RE: **Amendment to an Approved Subdivision to Create 2 Phases  
Skylark Commons 17-lot Subdivision**

Address: Skylark Road and Coolidge Avenue in the vicinity of 87 Skylark Road  
CBL: 347 D001  
Application ID: HTE 10-98900002 (amendment to #2004-0252)

# PLANNING BOARD REPORT PORTLAND, MAINE

Amendment to an Approved Subdivision to Create 2 Phases

Drawing file: 1. Original Plans / Amendment July 27 2010.pdf

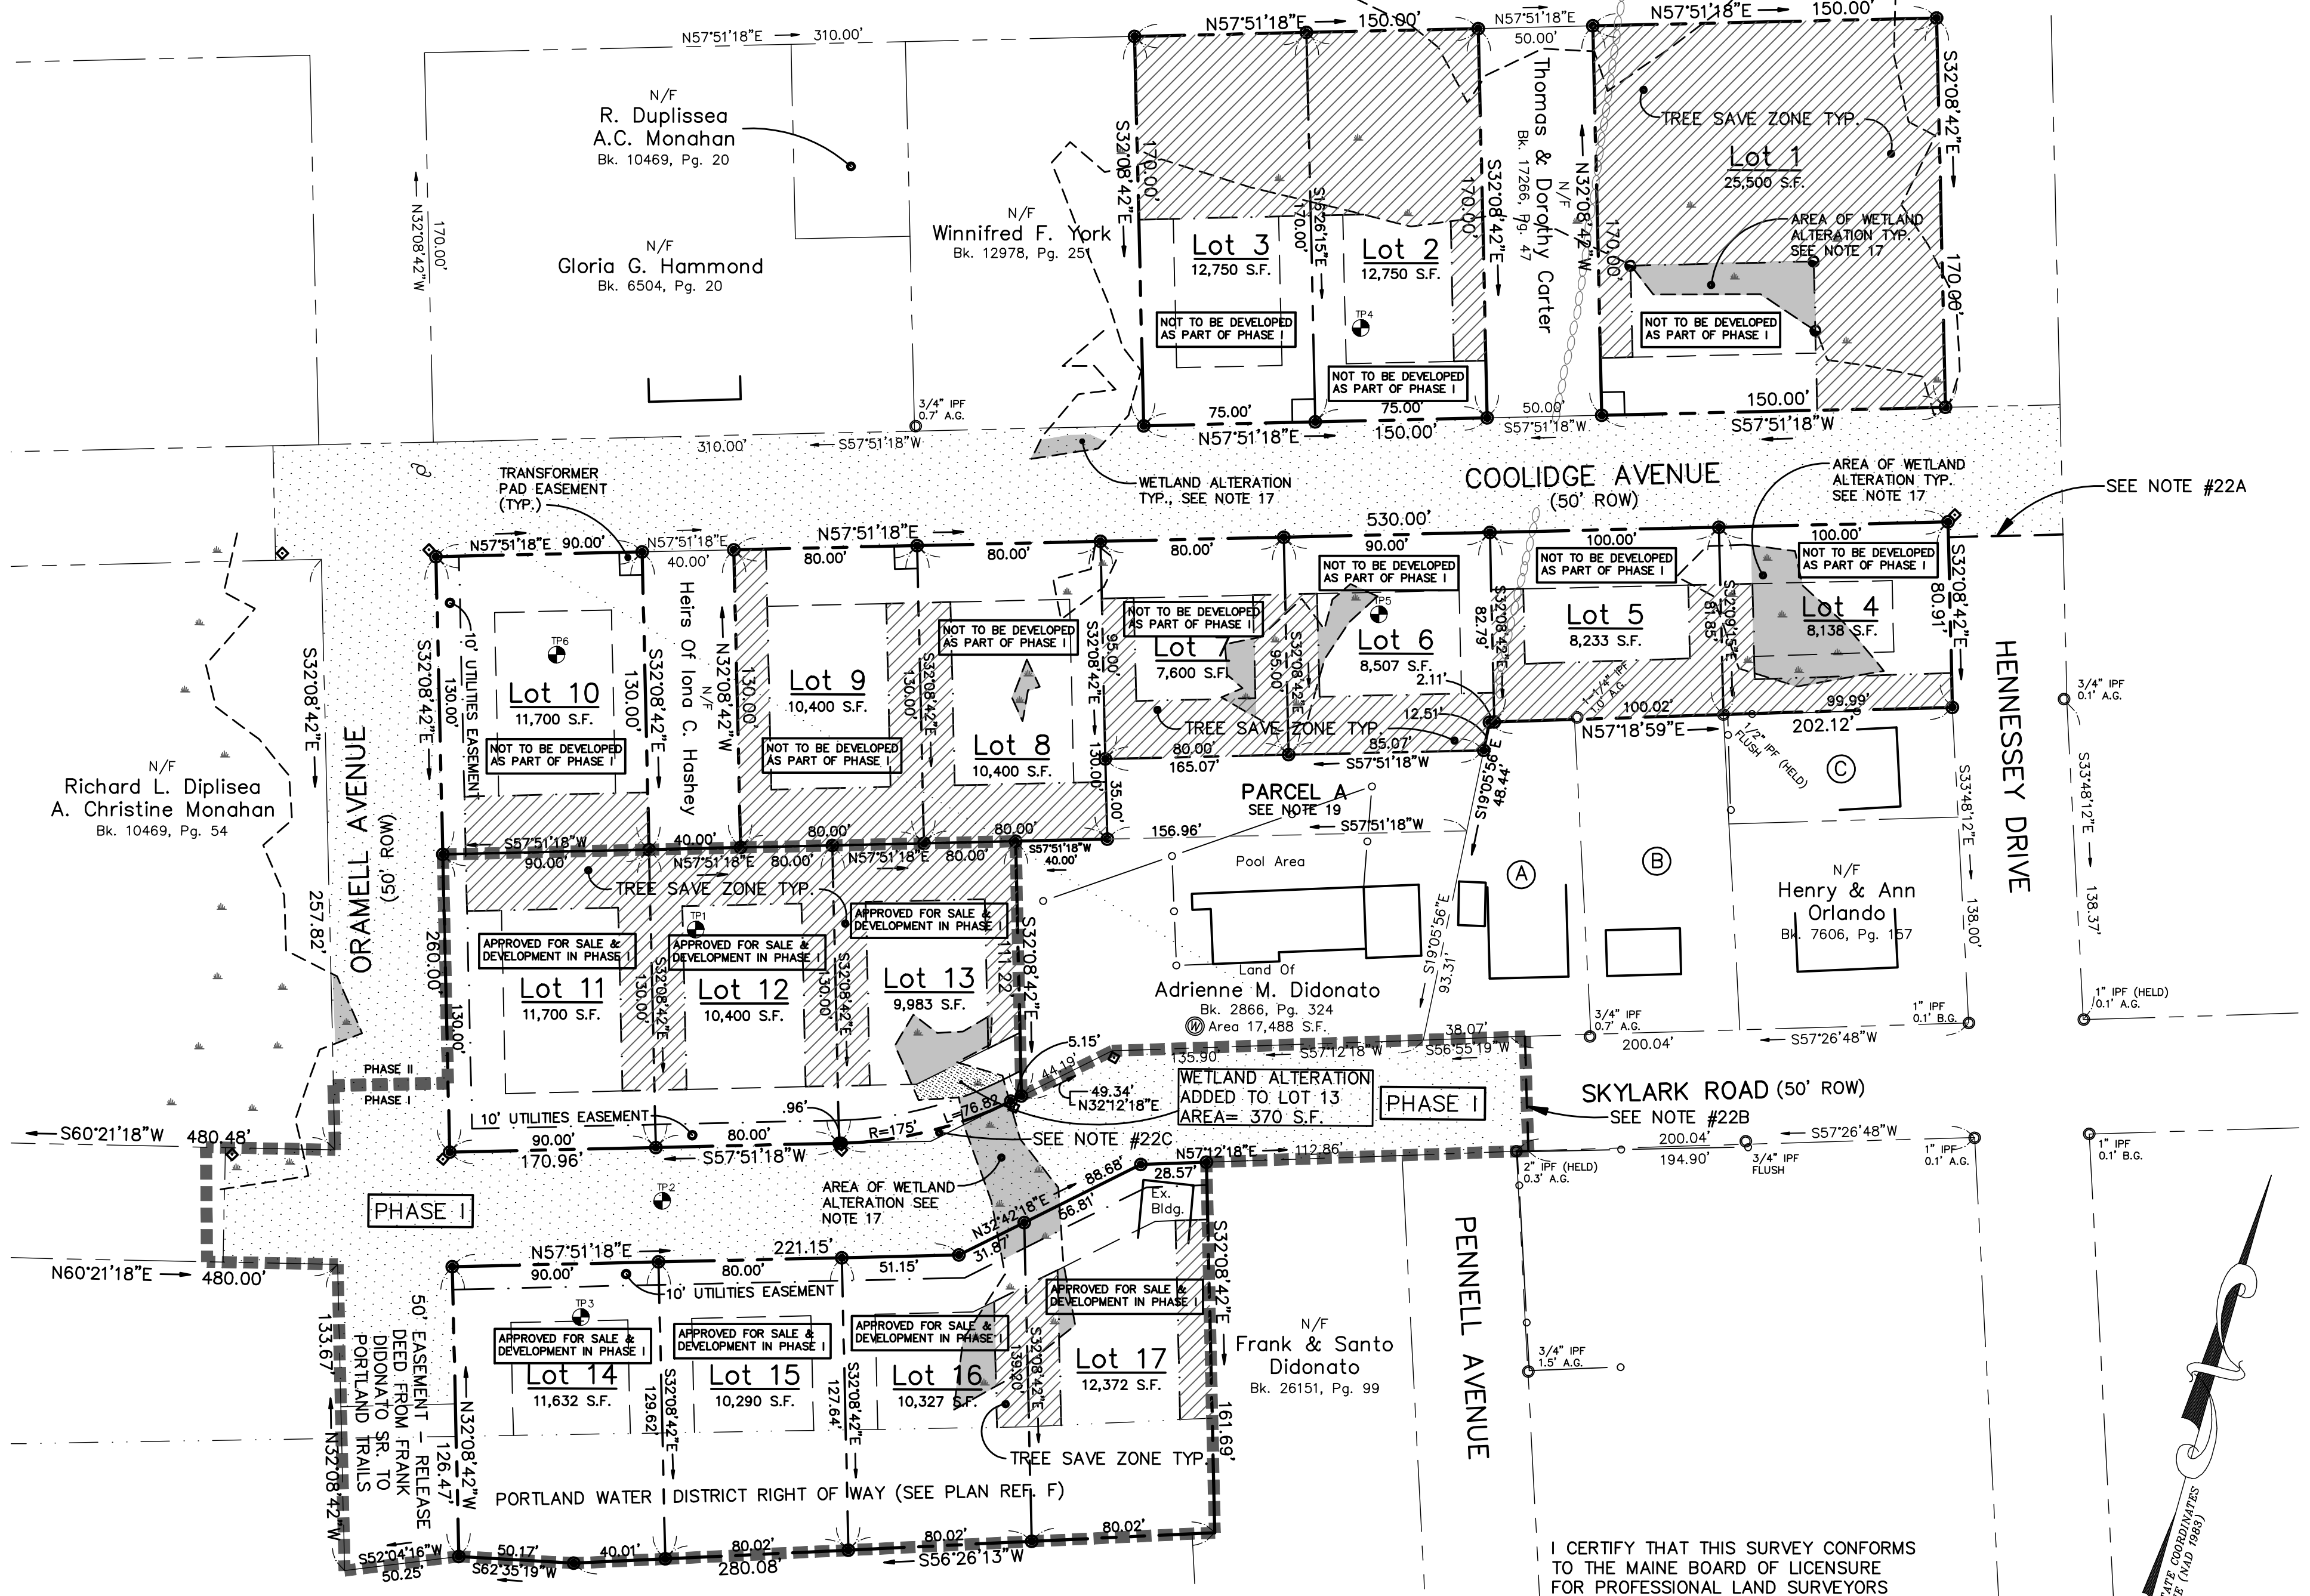
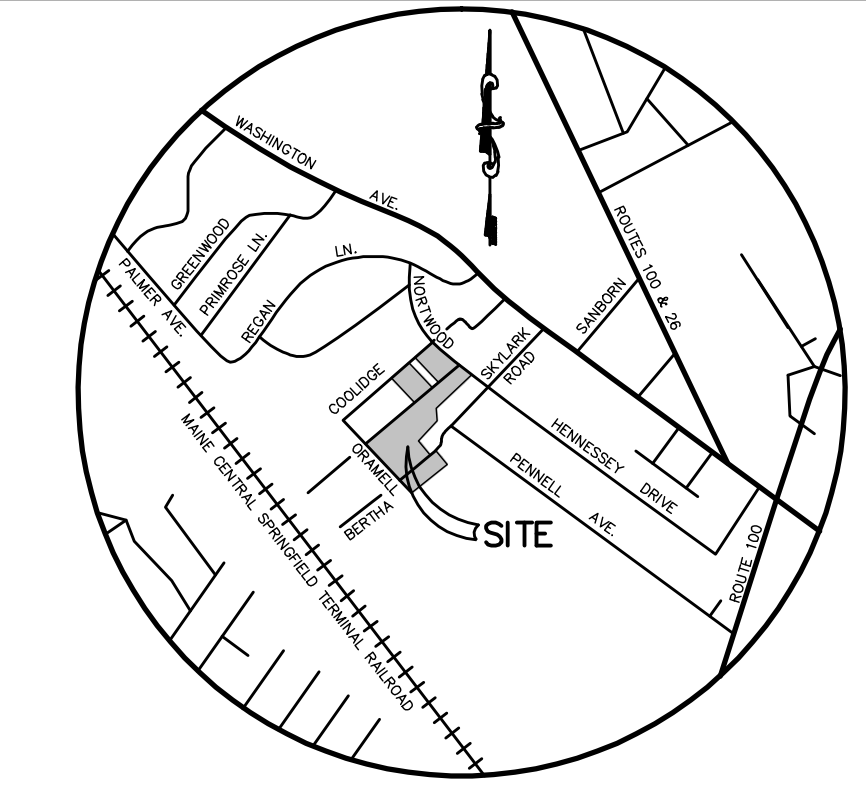
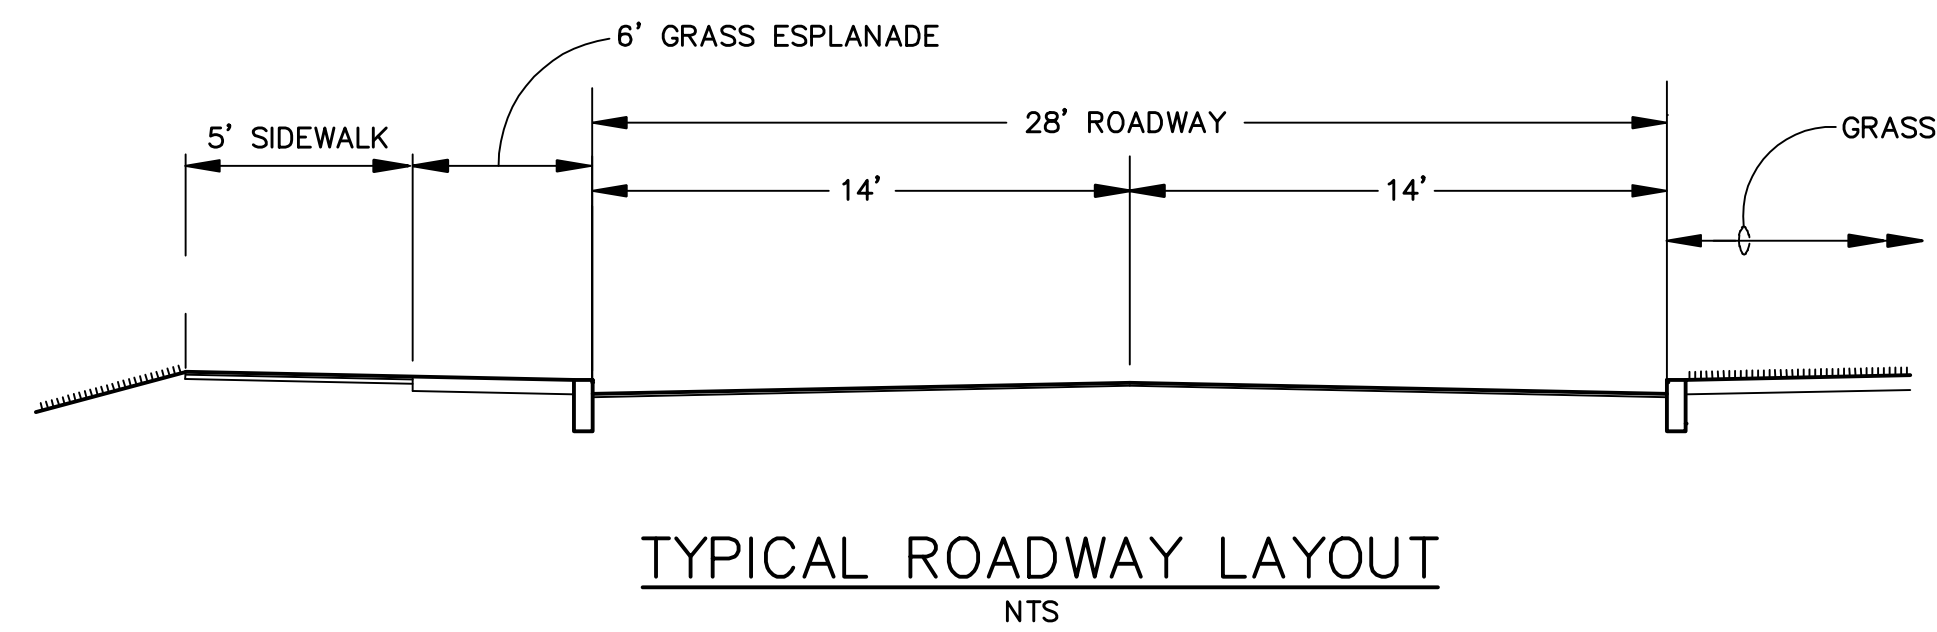
- iii. That the applicant shall add a note to the *Amendment to the Approved Subdivision Plat* that states that a Performance Guarantee and Inspection Fee in respect of Phase II must be paid prior to the issuance of a building permit for any part of Phase II improvements; and

- iv. That the applicant shall add a note to the *Amendment to the Approved Subdivision Plat* that sets out any MDEP Special Conditions of the NRPA Tier I Permit for the wetland filling; and

- xi. The recording plat shall be revised to reflect only lots 11-17 on Skylark Road as the approved lots in Phase I for sale and development, subject to the review and approval of the Planning Authority.
